MEMORANDUM

TO: Jean Fraser, Planner
FROM: Lauren Swett, PE
DATE: August 30, 2017
RE: One Joy Place, Level III Site Plan Application

Woodard & Curran has reviewed the Level III Site Plan Application for the proposed development located at 1 Joy Place in Portland, Maine. The project involves the demolition of an existing vacant single family home and the construction of a proposed 12-unit condominium and associated improvements to Joy Place a Private Road accessing the site.

BRICK SIDEWALK SECTION

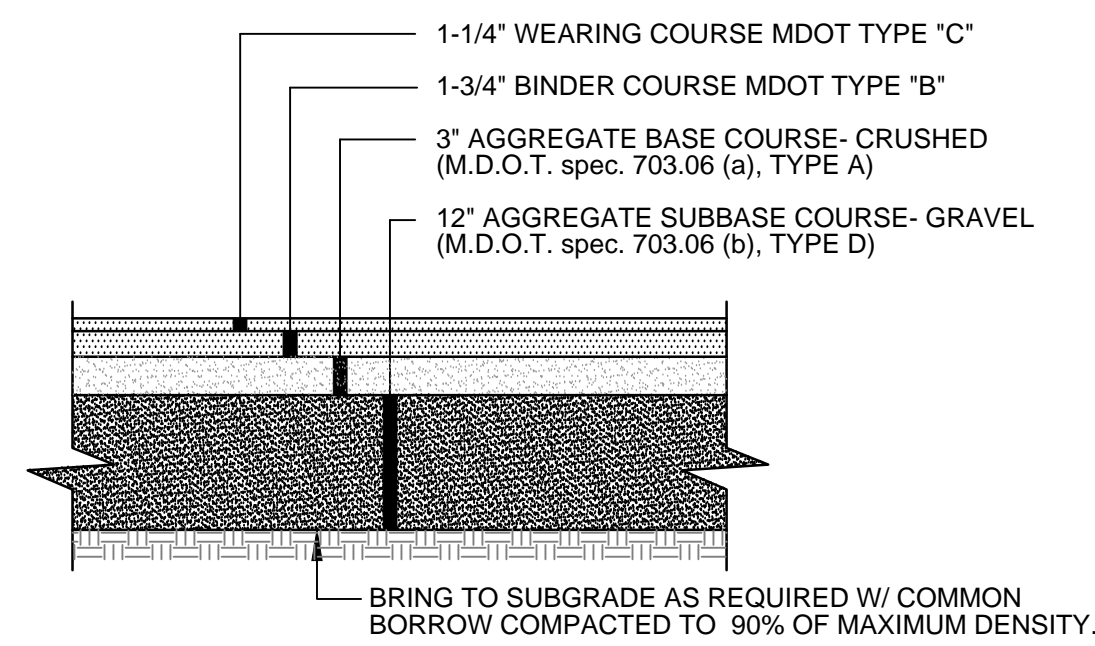
- 4) All work within the City Right-of-Way is required to comply with City of Portland Technical Standards. Brick sidewalk and pavement details for work within the right of way should be in compliance with the Technical Standards.

BRICK DRIVEWAY APRON

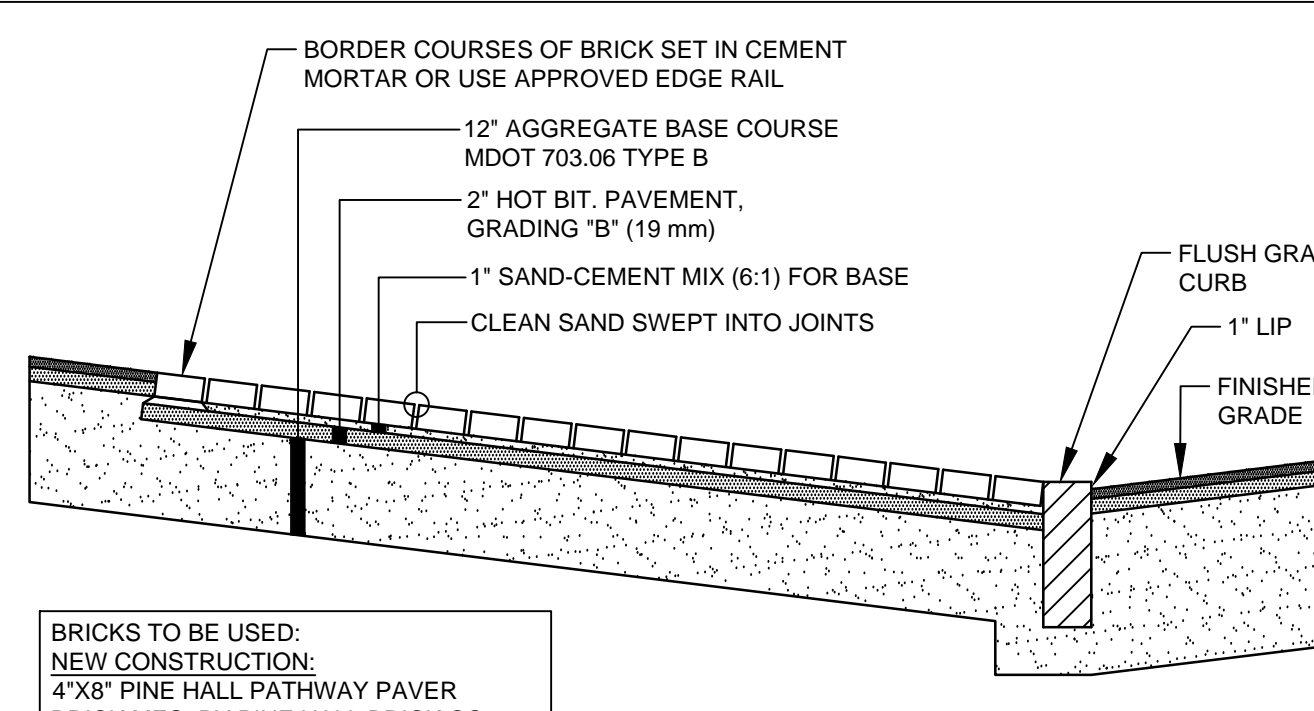
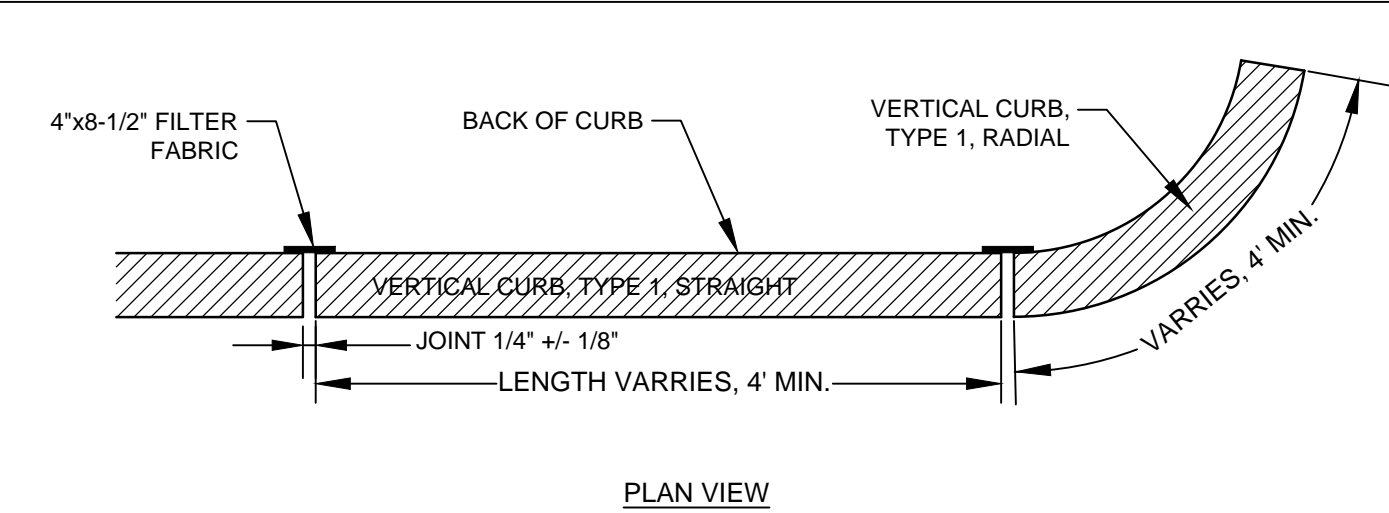
- 2) The detail and plan view provided for the brick driveway apron is not in conformance with the City of Portland's Technical Manual. The standard requires a 12" bituminous strip at the base of the driveway where the Applicant is currently showing a flush granite curb. Any variation from the standard will require approval from the City.

TYPICAL TRENCH DETAIL
NOT TO SCALE

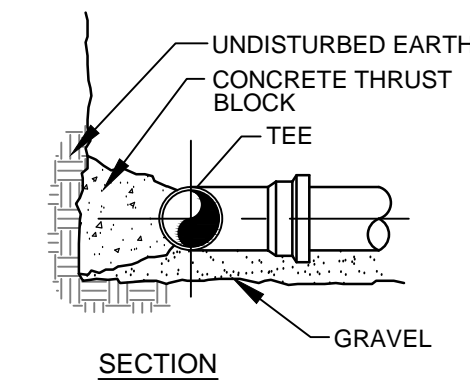
- 5) The pipe burial detail notes that minimum cover is 1 foot. It was noted that in some areas, cover over pipe will be less than 3'. Insulation should be provided in areas with minimal cover to prevent freezing.
